Reference:  
W8x21 Beam & Misc Framing  
88 Codman St.  
Portland, ME

Structural Integrity Job Number: 14-0138

FIRST FLOOR REFERENCE PLAN

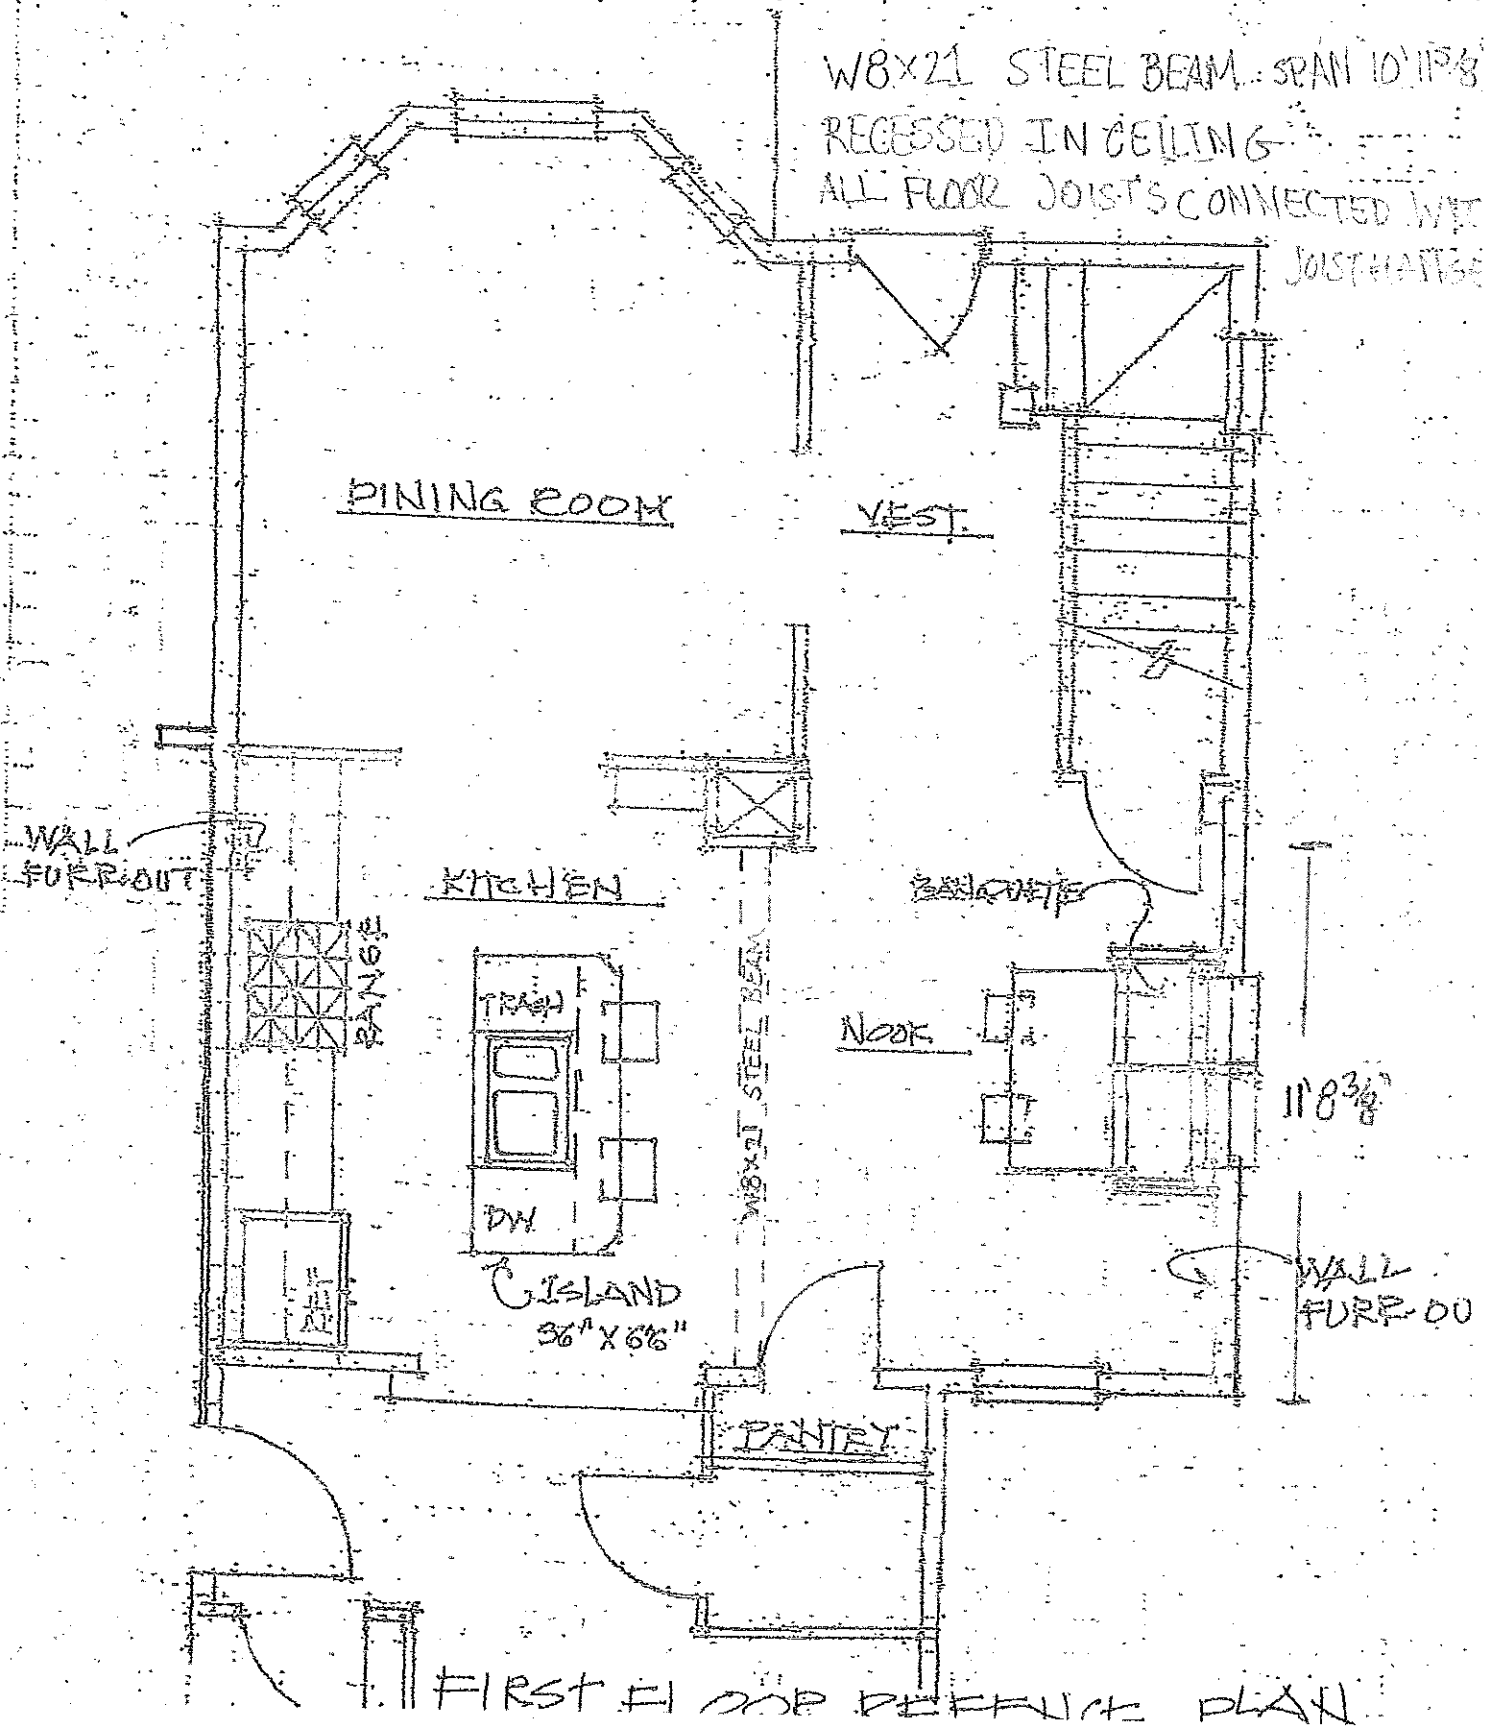
Based on my calculations, the plans provided, and my observations, I am of the opinion that the new W8x21 beam that used to support the existing second floor framing is adequate and associated framing is substantially complete.
